WEE HUR STUDENT VILLAGE 13-23 GIBBONS STREET REDFERN

RESPONSE TO SUBMISSION - SUPPLEMENTARY DESIGN REPORT

Item	Notes	Chapter
SDRP Comments from meeting of 16/03/20		
Demonstration of Design Excellence	A request to bring 13-23 Gibbons Street (SSD-9194) to the SDRP for a third review session was made on 06/01/20 and declined by GANSW on 14/01/20. Following SDRP2 GANSW recommended that the project not return until an FSR compliant model could be presented. The proposal remains FSR non-compliant. Additionally, it was almost 18 months since the project had last been seen by the Panel (3/10/18) and the assessment process was well underway.	
	GANSW's last advisory letter as informed by the SDRP states that the scheme as proposed (with increased floor area over allowable) is not leading to a design excellent outcome. Notwithstanding some improvements since this time, this position has not changed. We note the following: + the site is highly constrained + achieving a design excellent outcome in these conditions is therefore highly challenging + any proposal which seeks additional FSR beyond allowable must work even harder to achieve a design excellent outcome.

Department of Planning RFI

SOUTHERN FACADE PRIVACY

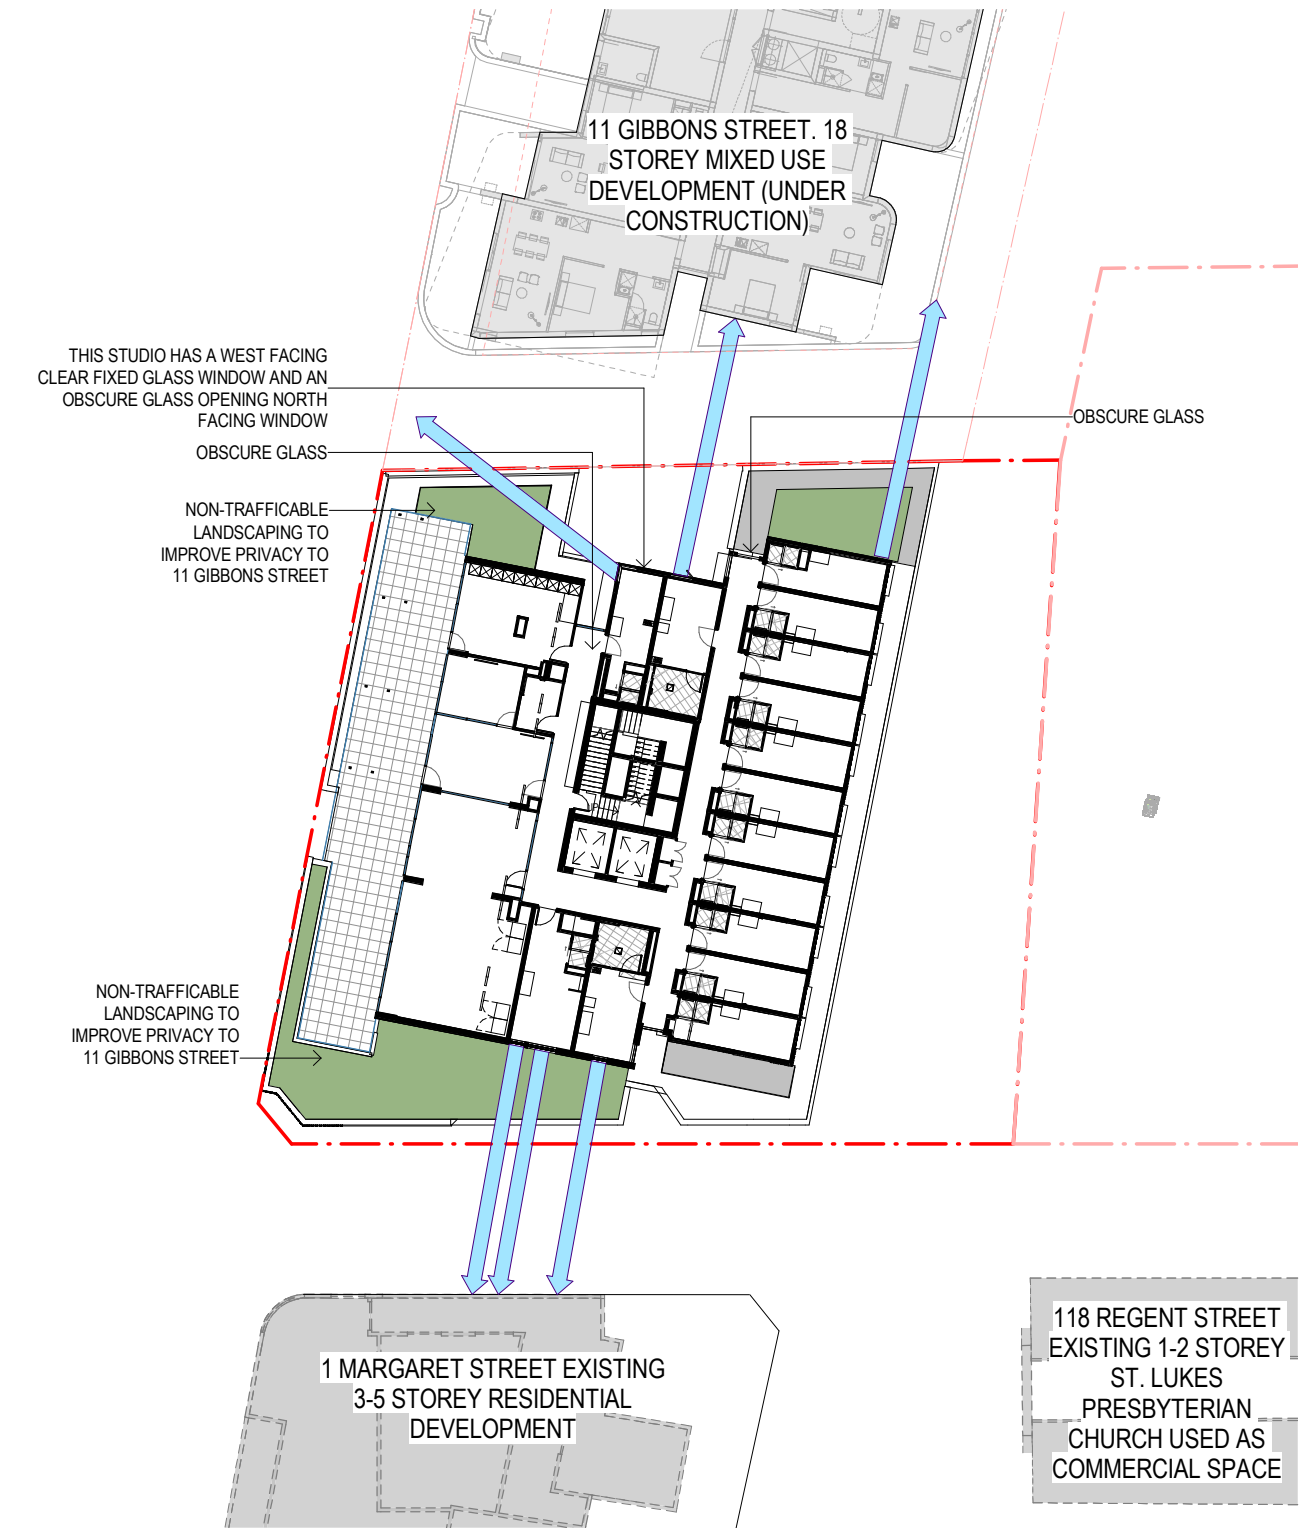
Further, the ground floor southern façade is predominately blank resulting from the use of vertical aluminium fins that screen the common rooms.	Chapter 2, p31
	The awning over the entry on Gibbons Street does not offer weather protection due to its height. An awning over the entry is needed to protect pedestrians from downdrafts and rain.	
	There is an awning proposed on the south eastern corner which partially hangs over the footpath and the planted area. This offers no continuous protection to pedestrians.	DA2001

Figure 10: Podium line within the Gibbons Street streetscape
(source AJ+C Architects Supplementary Design Report)

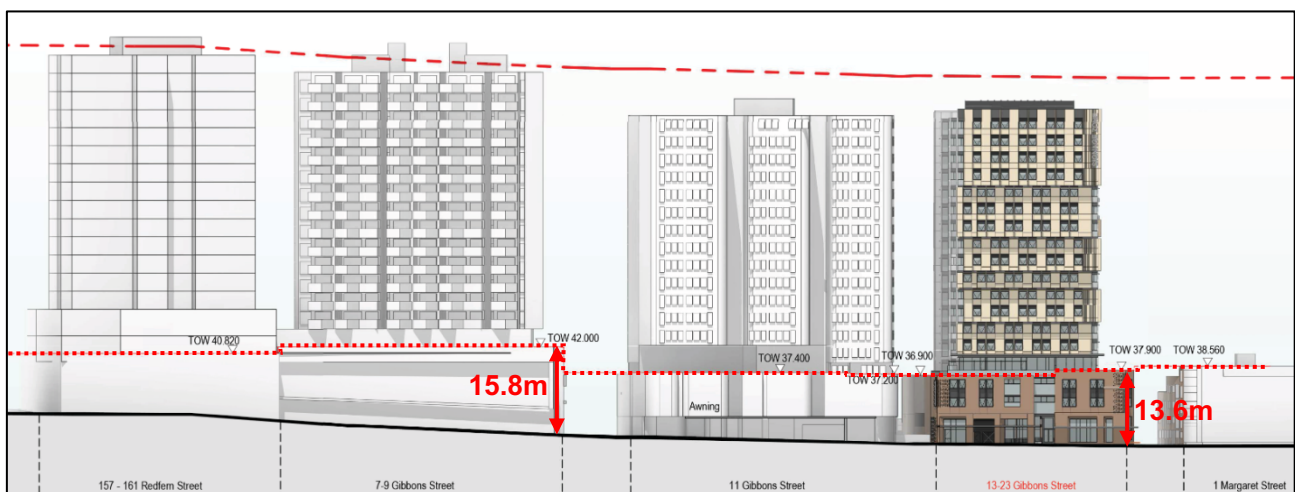
2. Podium height	Provide an assessment and contextual analysis of the increased podium height in Gibbons Street, noting the Redfern Centre Urban Design Principles require podium heights to respond to the parapets/RLs of existing buildings to create symmetry/consistency across streets and laneways.	Chapter 3, p39
